Project #: 1008255

Application #: 13DRB-70543

Project Name: SANTILLA PLACE

**RE: Lots 2-19, Block 2, Santilla Place**

SKETCH PLAT  
of  
Lots 2 thru 19, Block 2  
Santilla Place  
August, 2012

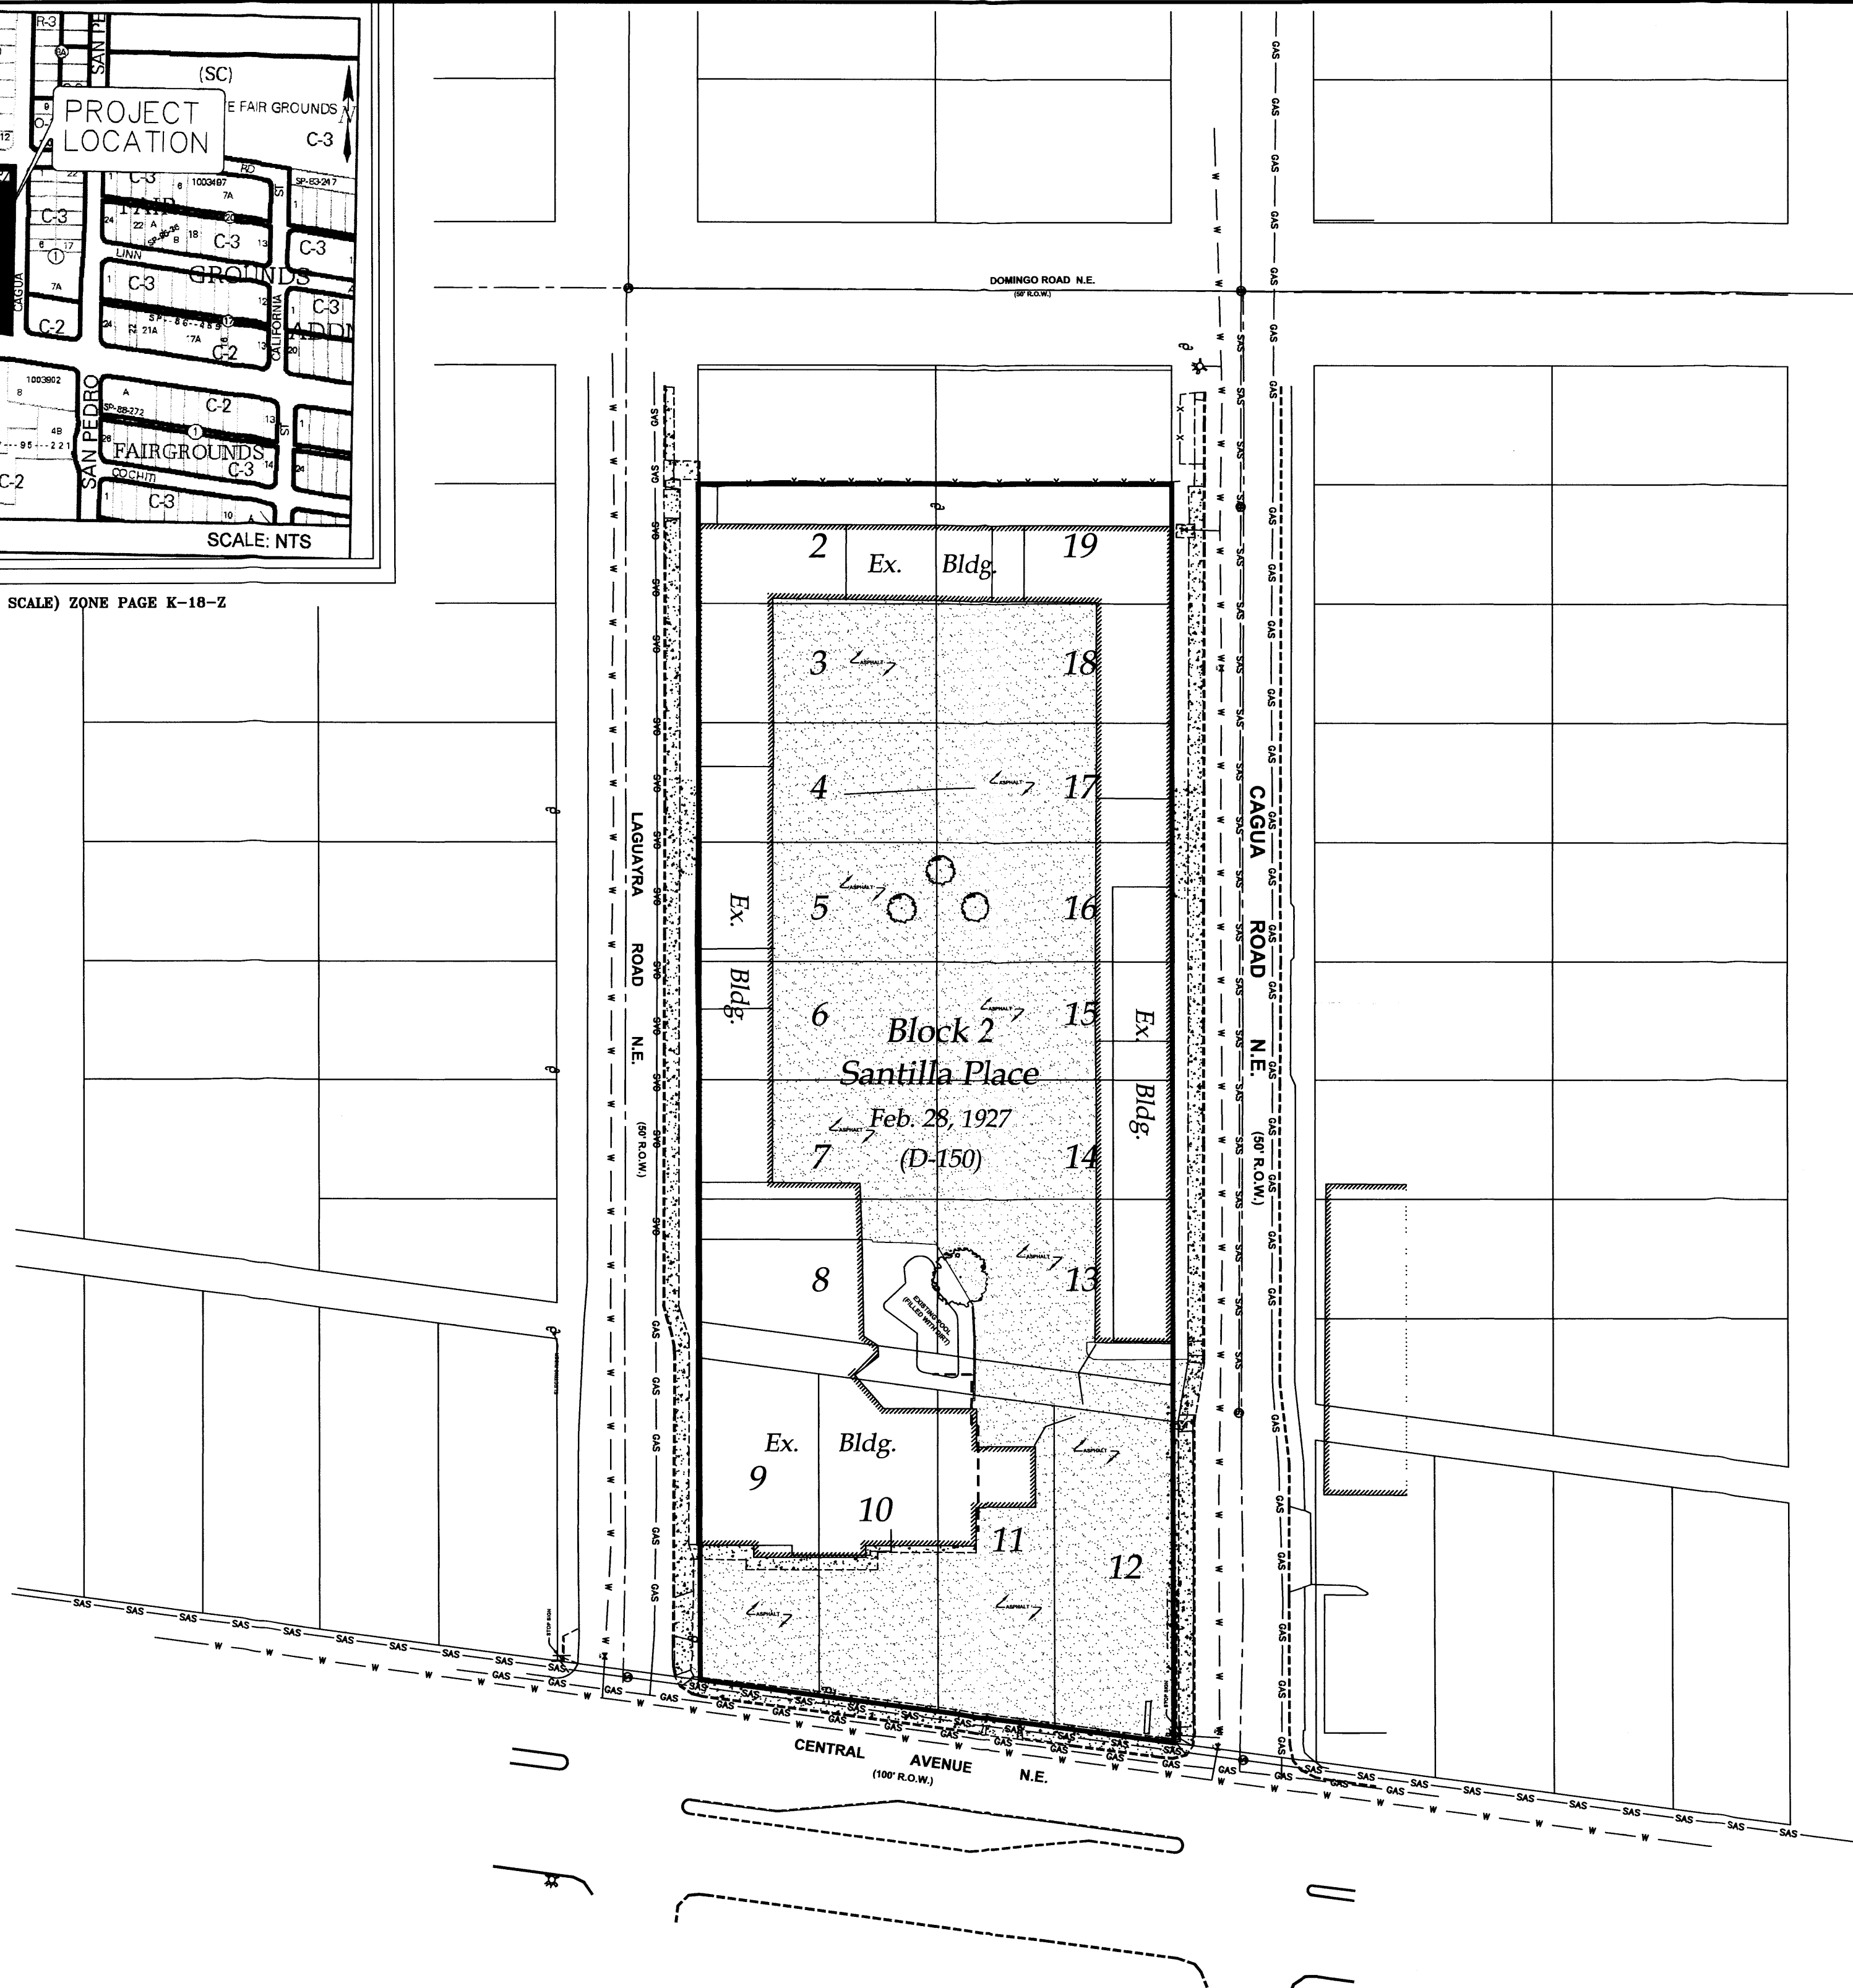
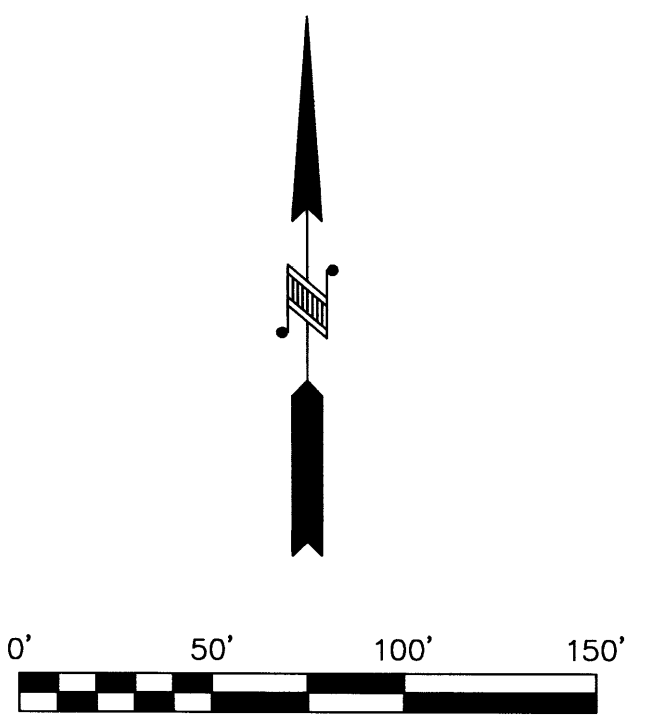
Lots 8-12 define the zone boundary for this block; they should be platted as a separate tract, or a zone change should be completed to plat this site as a single tract.
